File No: NTH22/00093/03

Your Ref: SSD-10360337

**RE: RESPONSE TO SUBMISSIONS – ST PHILLIPS CHRISTIAN CESSNOCK COLLEGE –
ALTERATIONS & ADDITIONAL INCREASE TO 1,732 STUDENTS - 10 LOMAS LANE & 210
WINE COUNTRY DRIVE NULKABA**

TfNSW has reviewed the RTS and supporting documentation, and provides the following comments to assist the Department in finalising this assessment:

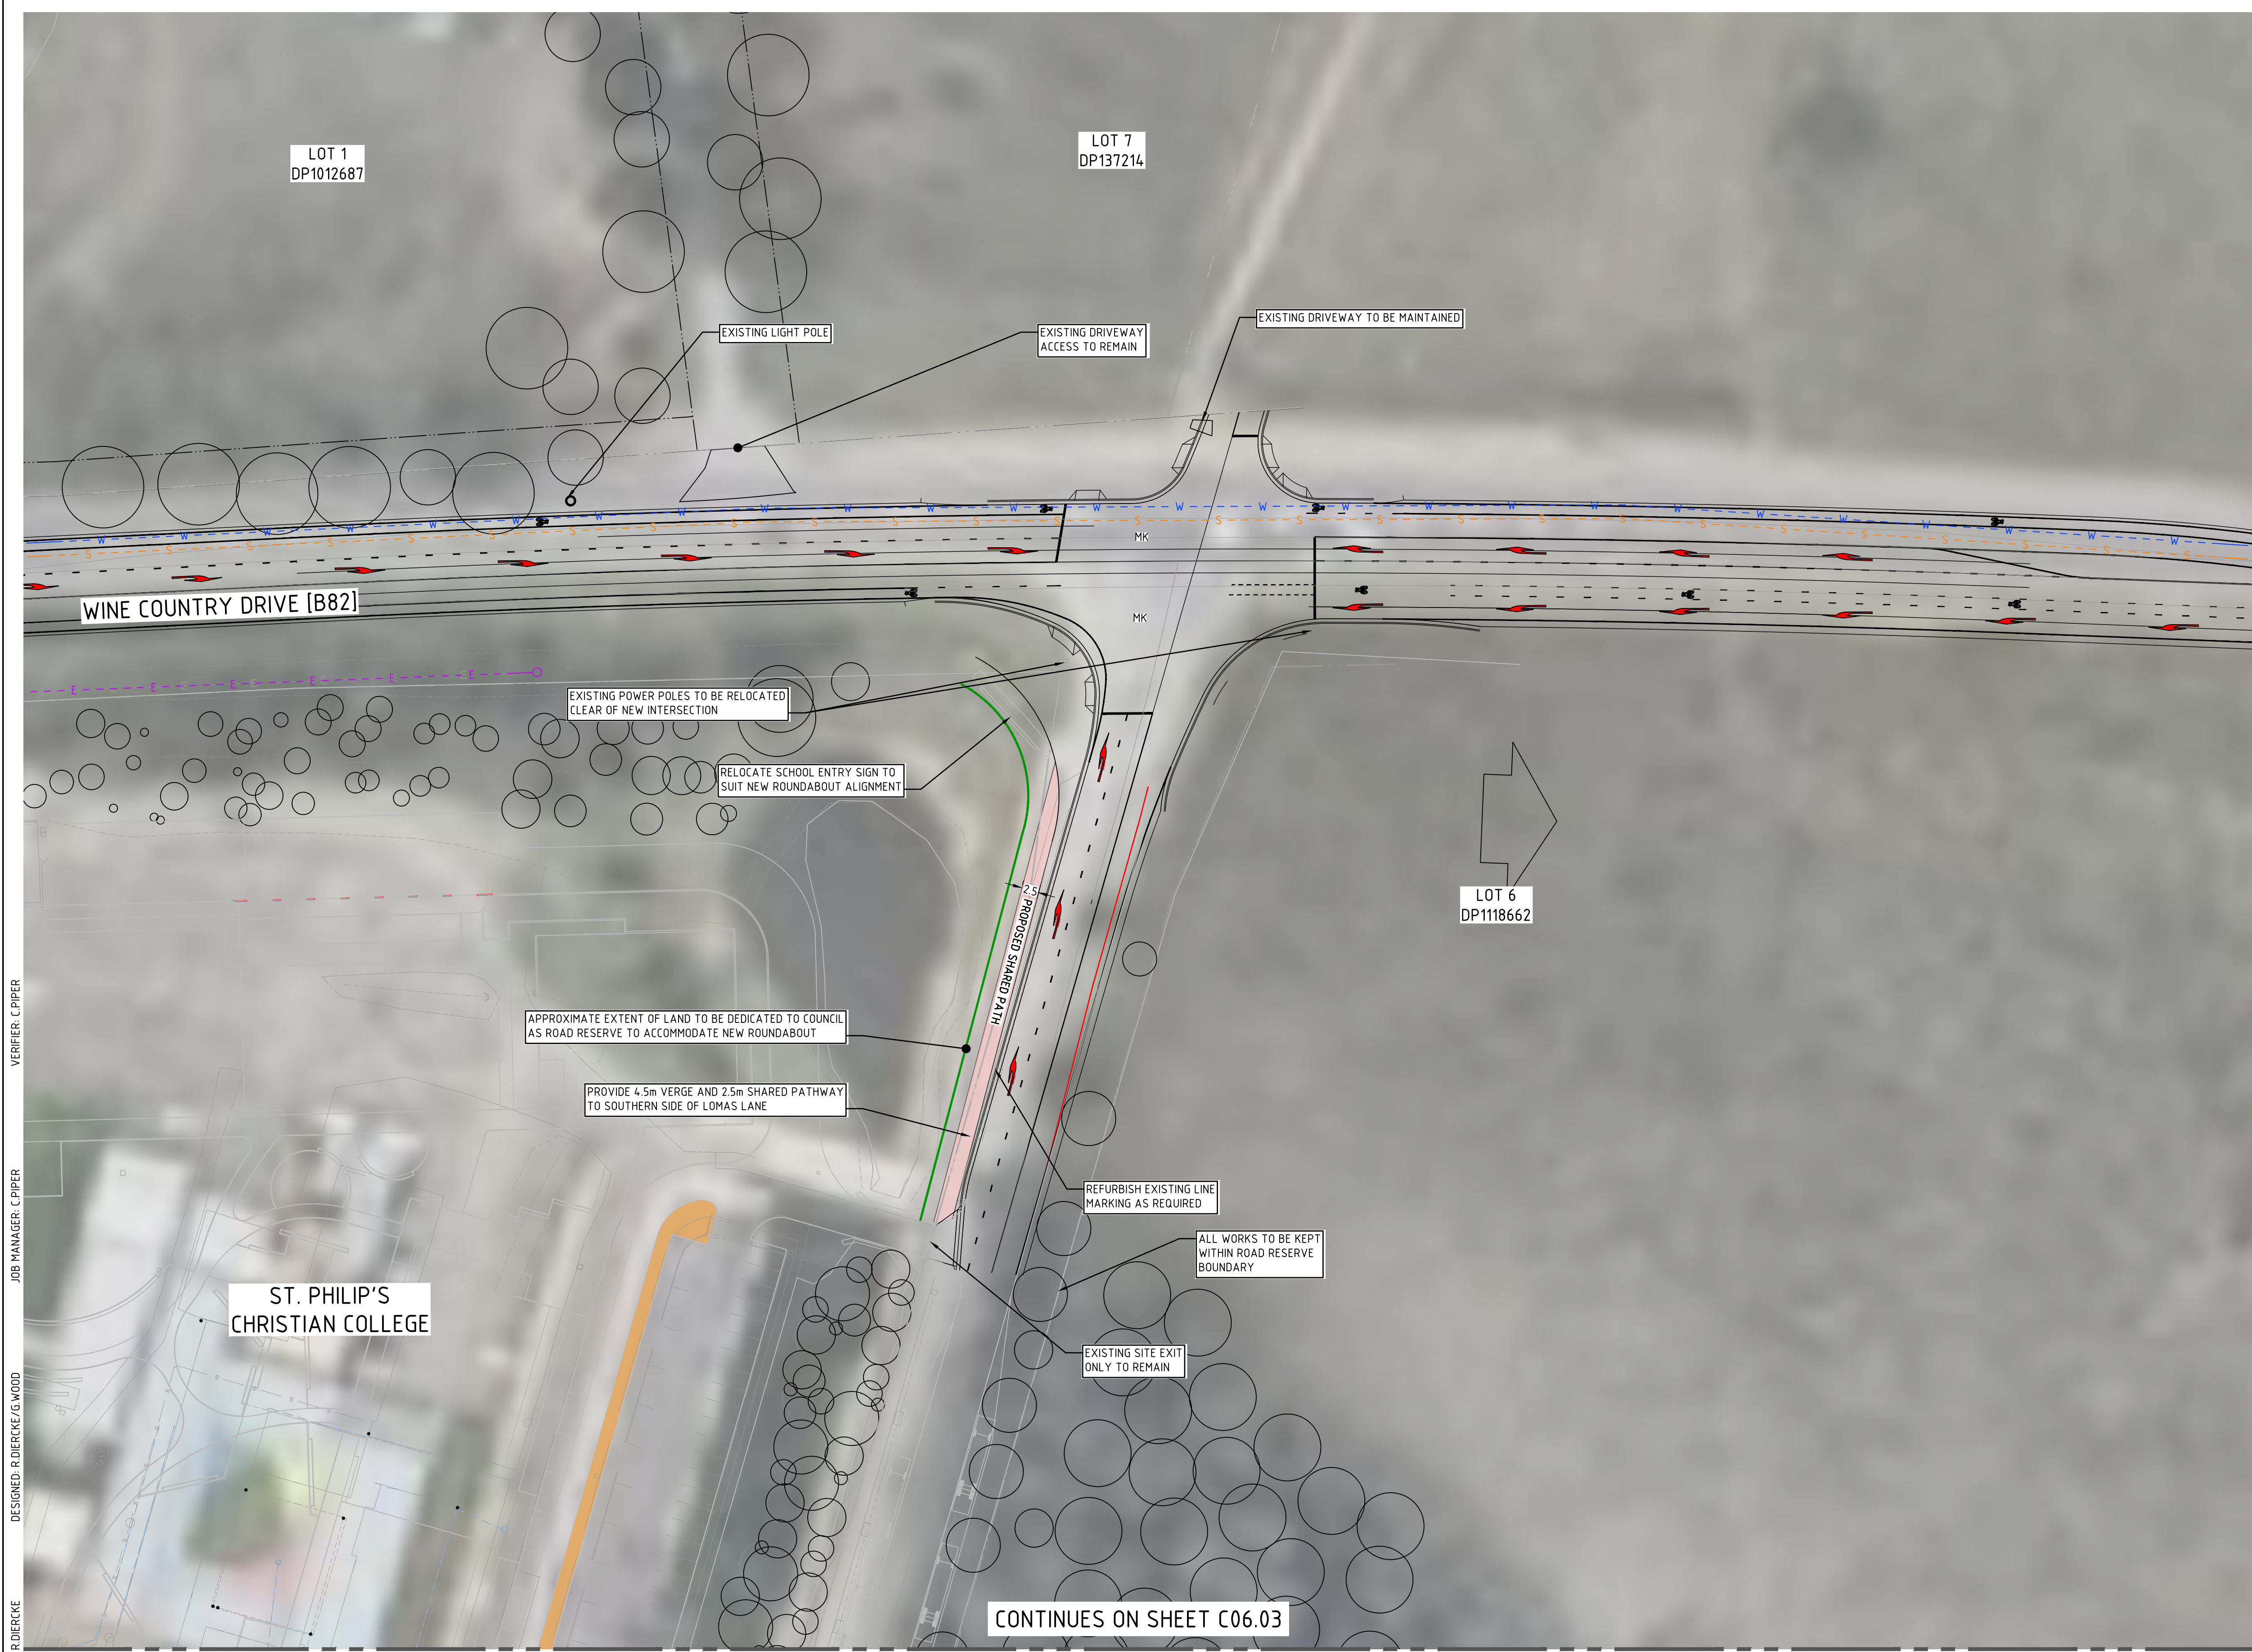
1. Traffic Control Signals – TfNSW is satisfied with this alternative tabled, subject to the consolidation of property accesses on the western side of Wine Country Drive (WCD) and any necessary property acquisitions. Upon the issue of any development consent, TfNSW will be able to issue the necessary Agreement in Principle (AIP) for this intersection.

2. Staging – No assessment has again been undertaken on how the State road network will operate between Stage 1A and upgrade of the WCD / Lomas Lane intersection (originally Stage 2 – RTS revised to Stage 1B). The works in Stage 1A introduce additional students on-site. Although traffic will be redistributed via the new southern WCD access, it is still envisioned that the WCD / Lomas Lane intersection will continue to operate at unsatisfactory levels and present safety concerns for all road users. It is again recommended that the upgrade of the WCD / Lomas Lane intersection be undertaken as part of Stage 1A.
